RESPONSE TO SUBMISSIONS

**Western Coal Services Project
State Significant Development 5579
Modification 1**

February 2017

Figure 10
 Springvale Water Treatment Project Overview

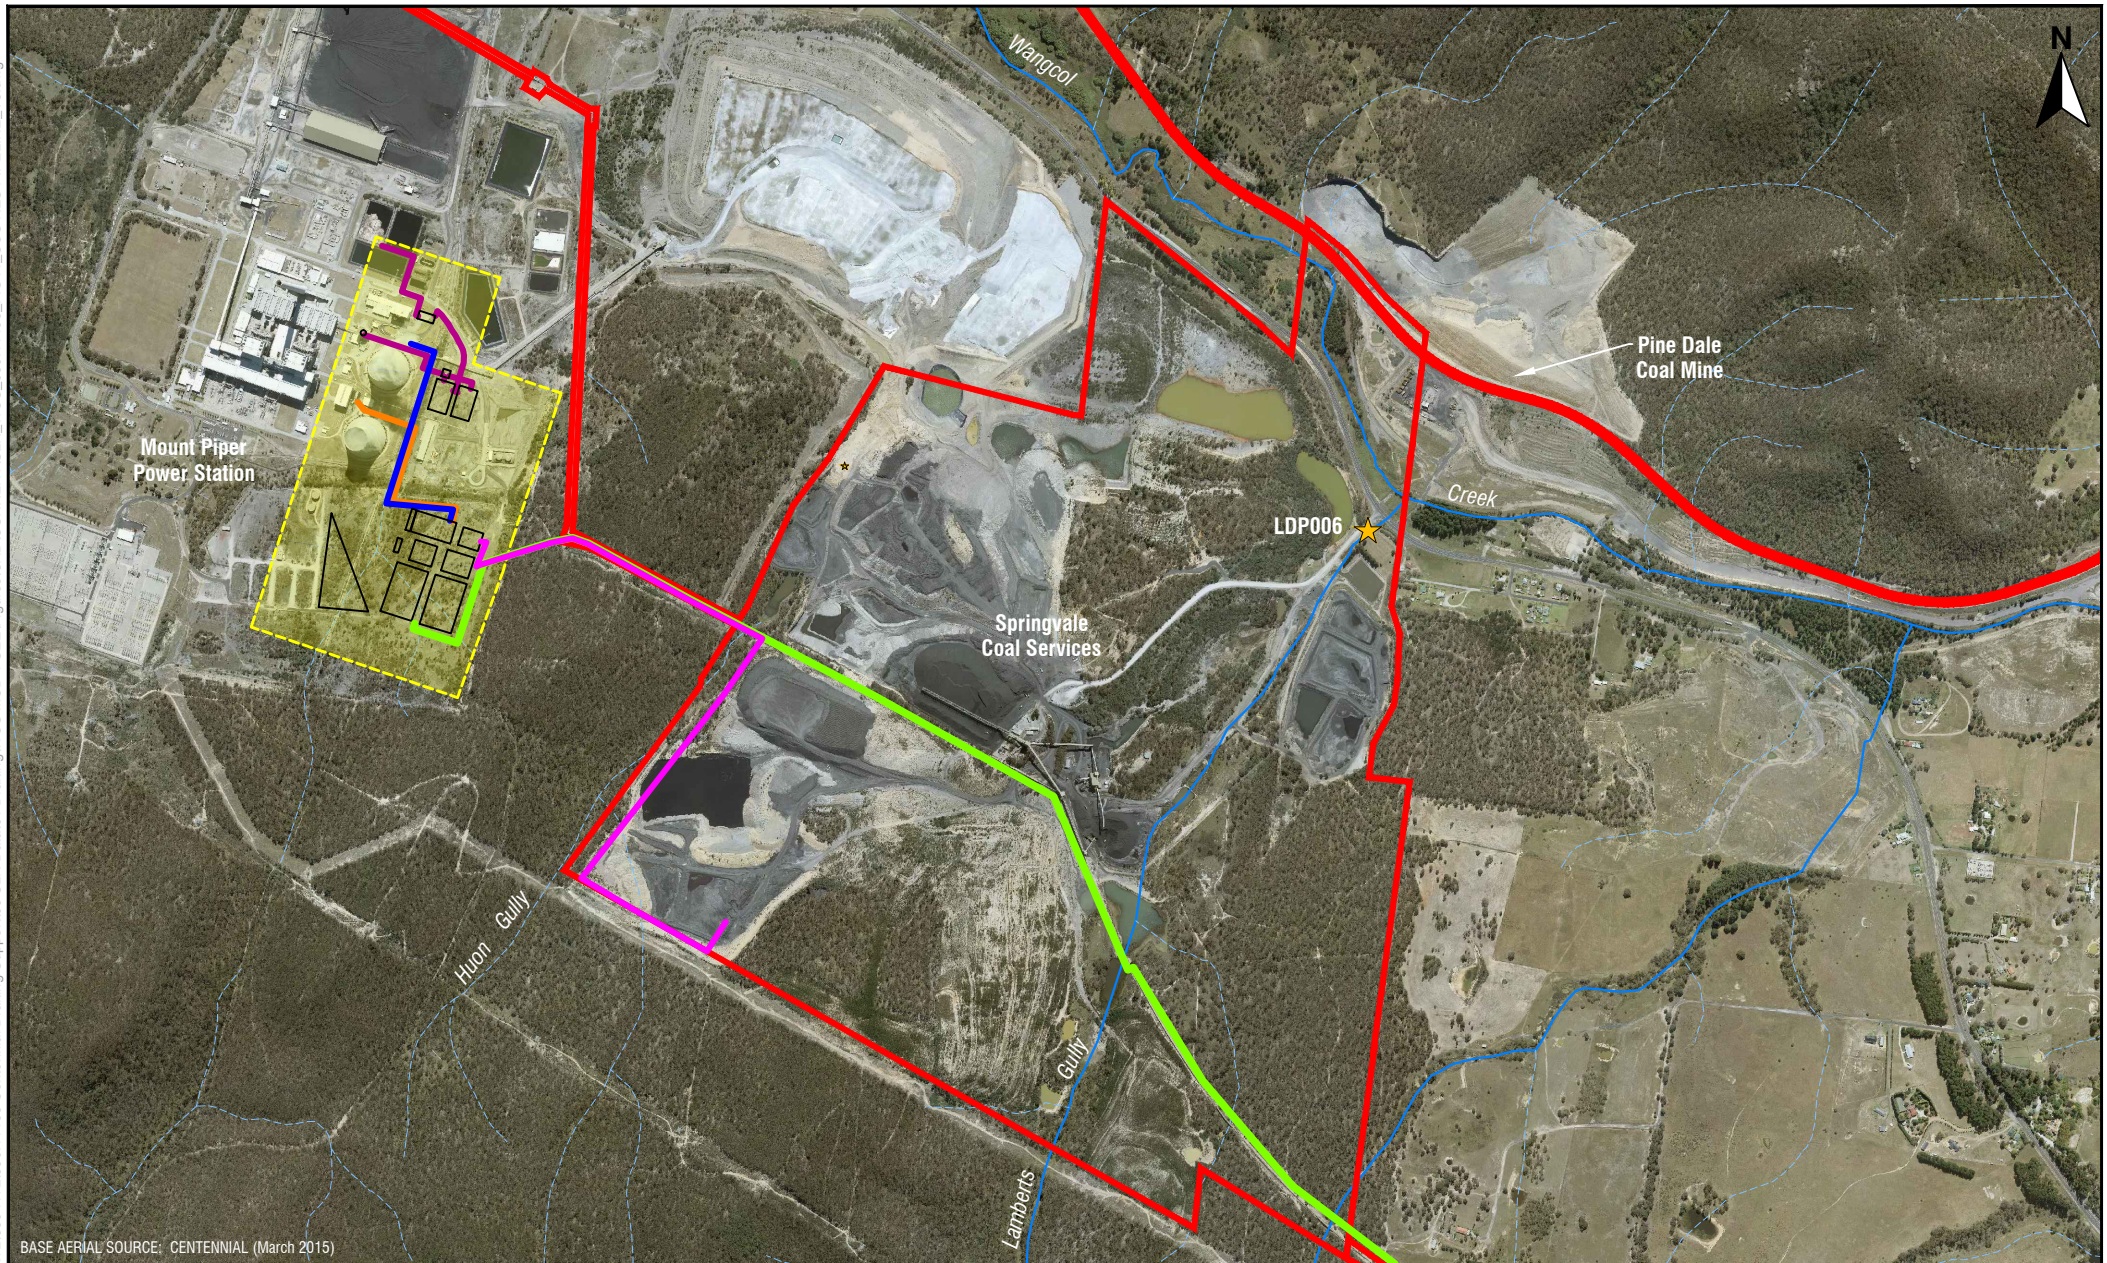
The EPA is seeking clarification on the exact location proposed for disposal of the residuals. Figure 5 of the main report titled 'Springvale Coal Services Site Infrastructure' shows the Co-disposal REA located near the main entrance on the eastern side of the site. Whereas Figure 11 of the main report titled 'Residuals Transfer Pipeline at Springvale Coal Services Site' shows the Residuals Transfer Pipeline terminating at the REA located on the southern boundary of the site.

The proposed Residuals Transfer Pipeline from the water treatment plant at MPPS will terminate within the new REA at the SCSS, as shown in Figure 10 and Figure 11 of the SEE. The residuals will be emplaced within the new REA, as discussed in Section 4.2.7 of the SEE.
